Arun District Council
Arun Civic Centre
Maltravers Road
Littlehampton
West Sussex BN17 5LF
Planning General Enquiries
Tel: (01903) 737756 Fax: (01903) 730442
Dx: 57406 Littlehampton
Minicom: 01903 732765
e-mail: planning@arun.gov.uk
website: www.arun.gov.uk/planning

21 August 2018

Town & Country Planning Act 1990 (as amended)
Town and Country Planning (Development Management Procedure) (England) Order 2015
Application for approval of details reserved by condition imposed under planning permission
EP/59/17/PL (Appeal no. APP/C3810/W/17/3183667) relating to condition No. 9 (Surface Water
drainage works) & 10 (Sustainable drainage scheme)
Tudor Lodge 125A Sea Road, East Preston,

Status :		APPROVAL	
Scales : as noted @ A1		Date : MAY.2018	
Drawn : DA	Engineer : VM	Checked : DL	
Drawing No. L2340-C-52-750		Revision 02

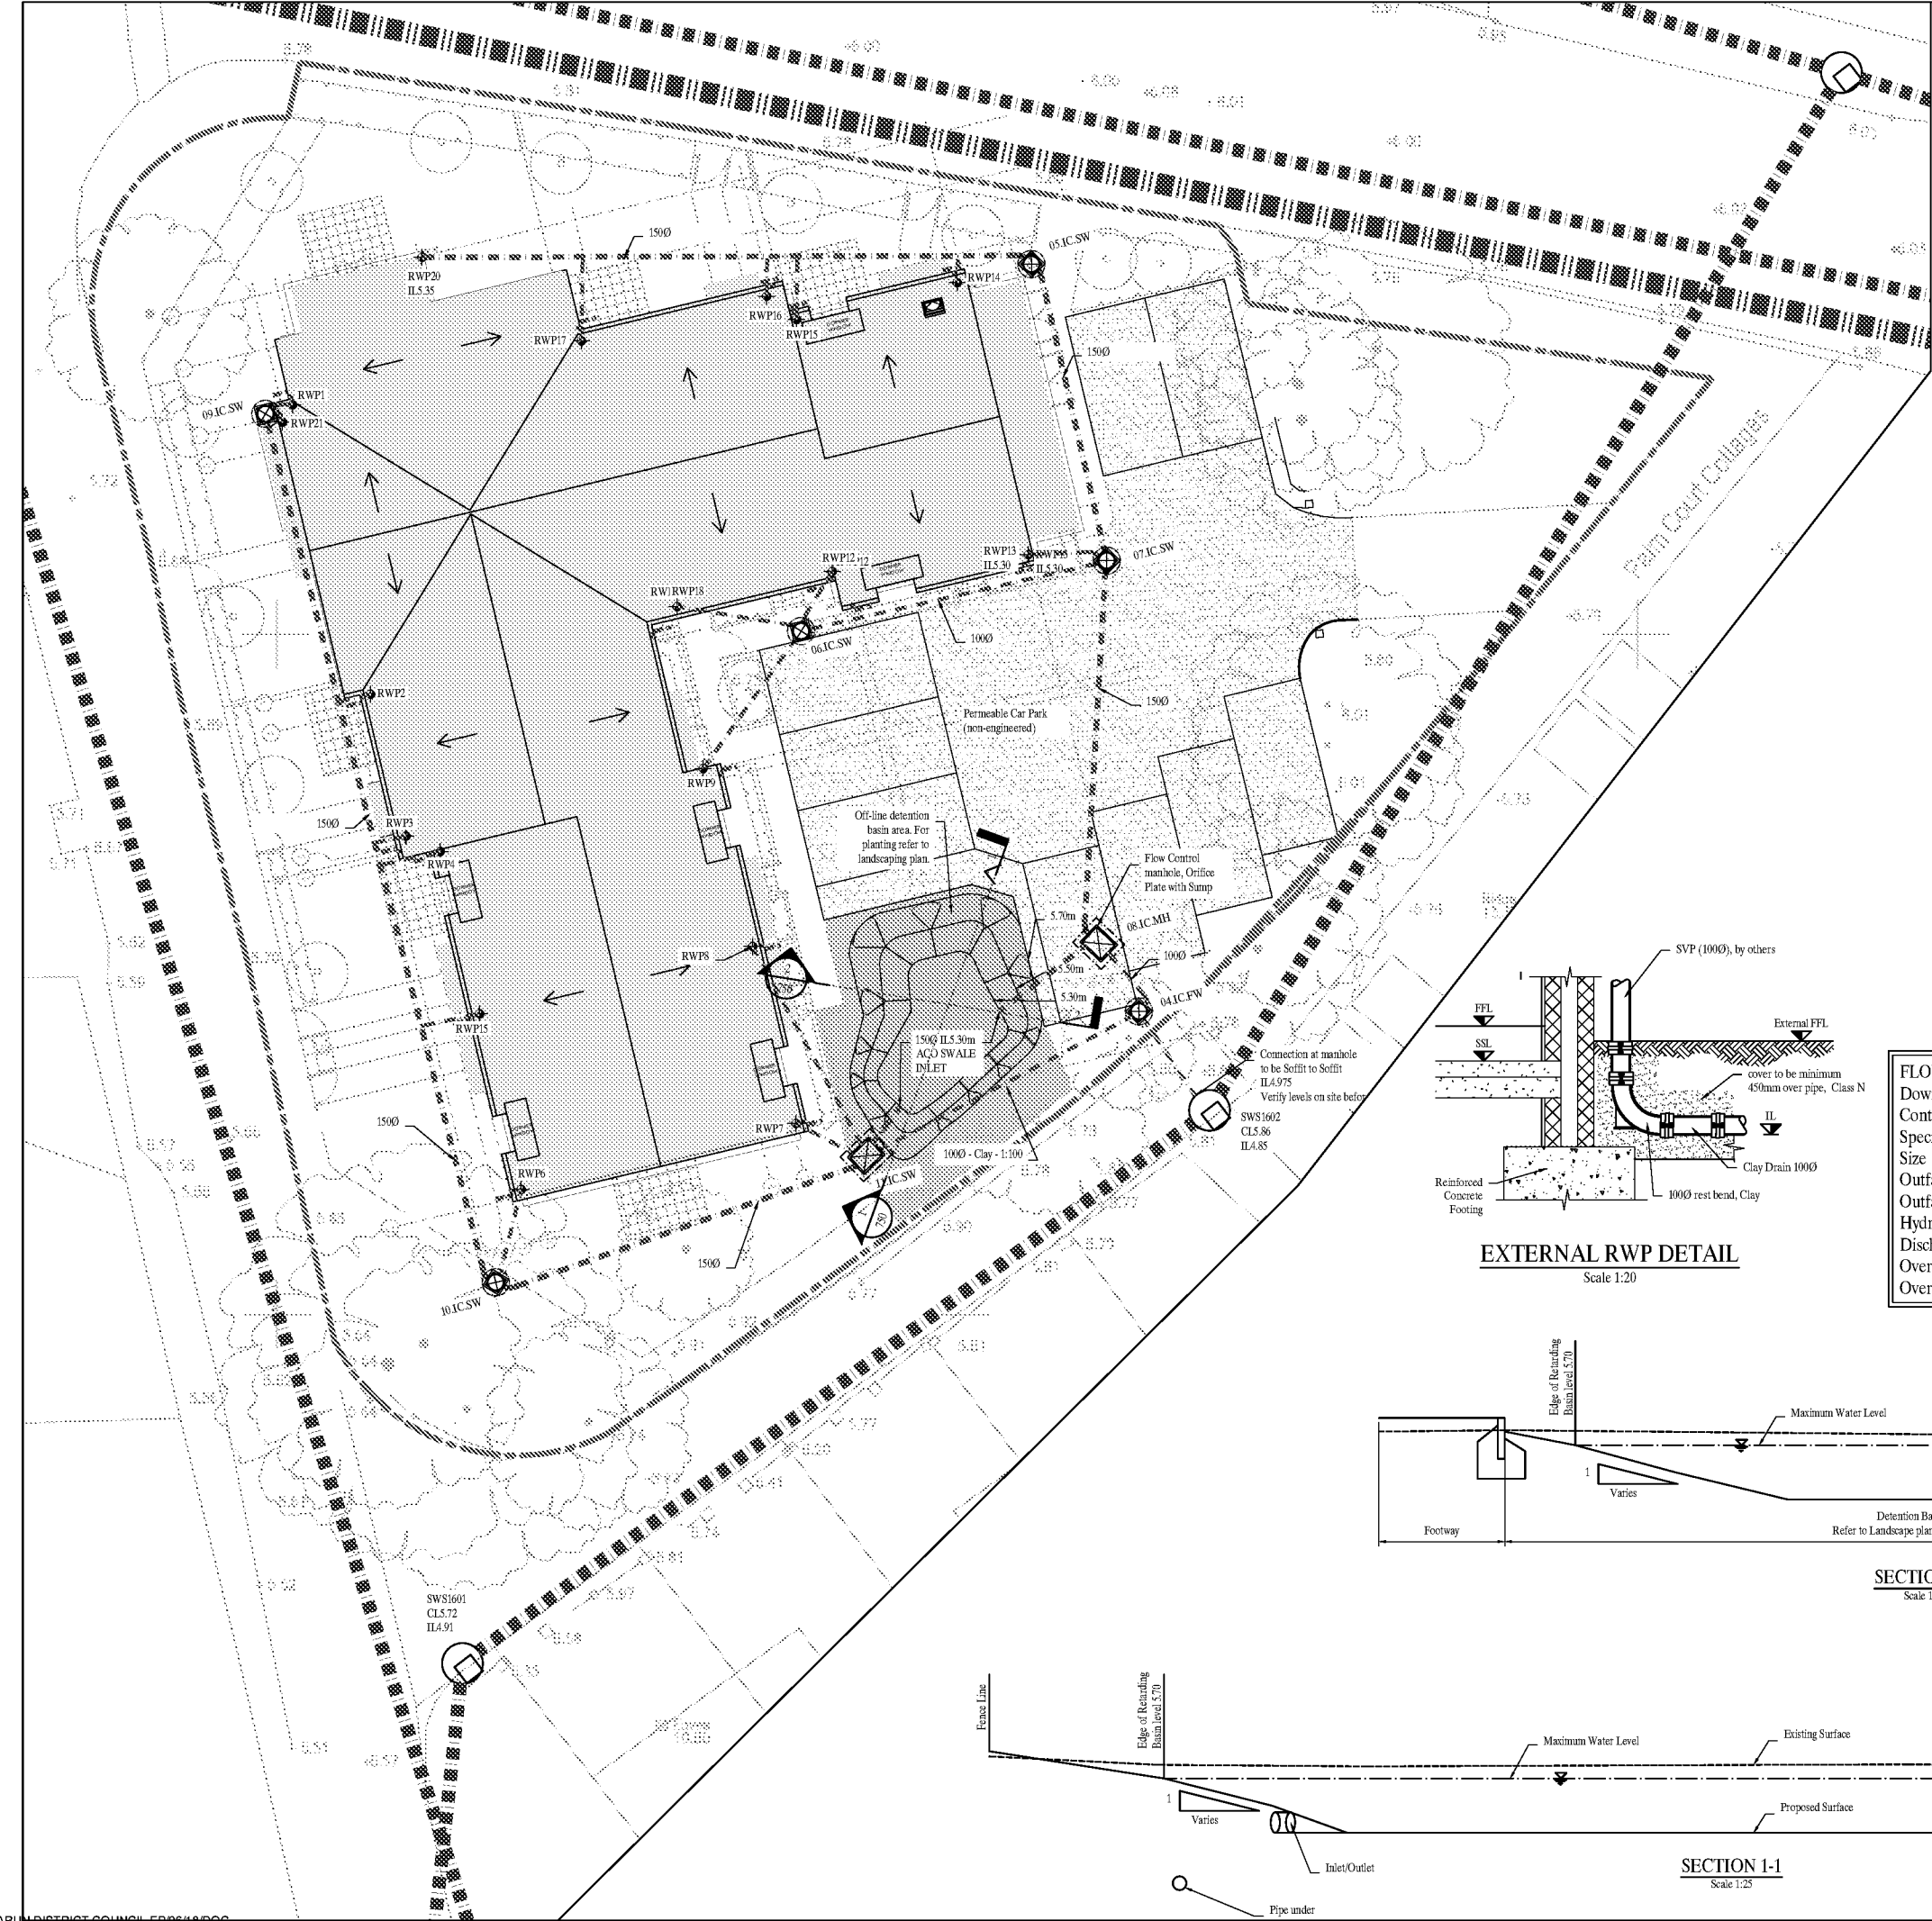
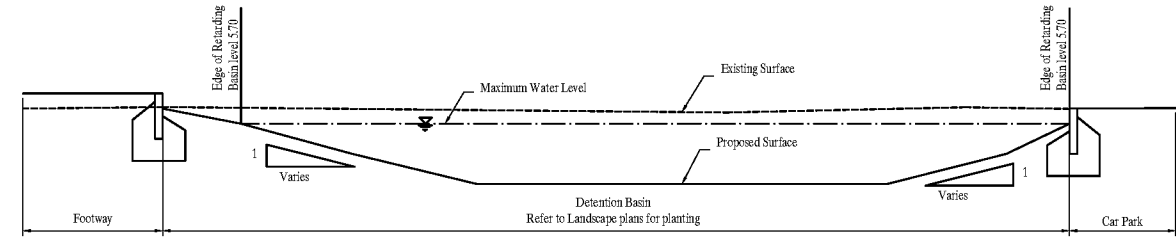
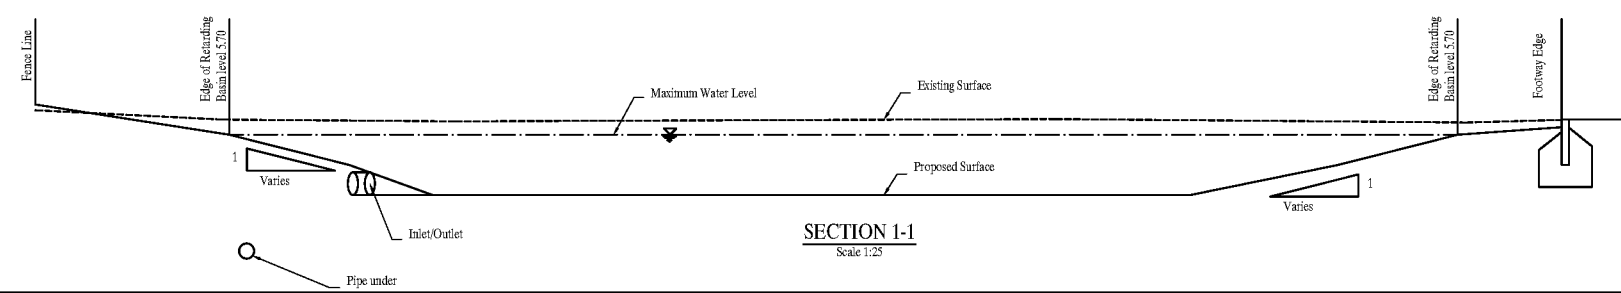
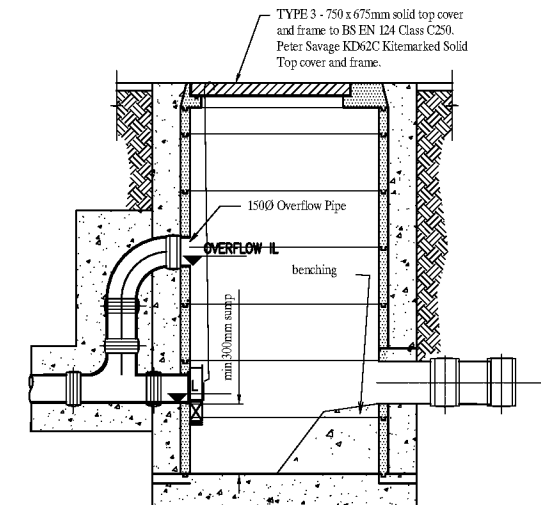
This application cannot be discharged. No winter infiltration test results have been provided to show that infiltration is not viable. Groundwater levels of 1.6m are not sufficient justification to rule out infiltration.
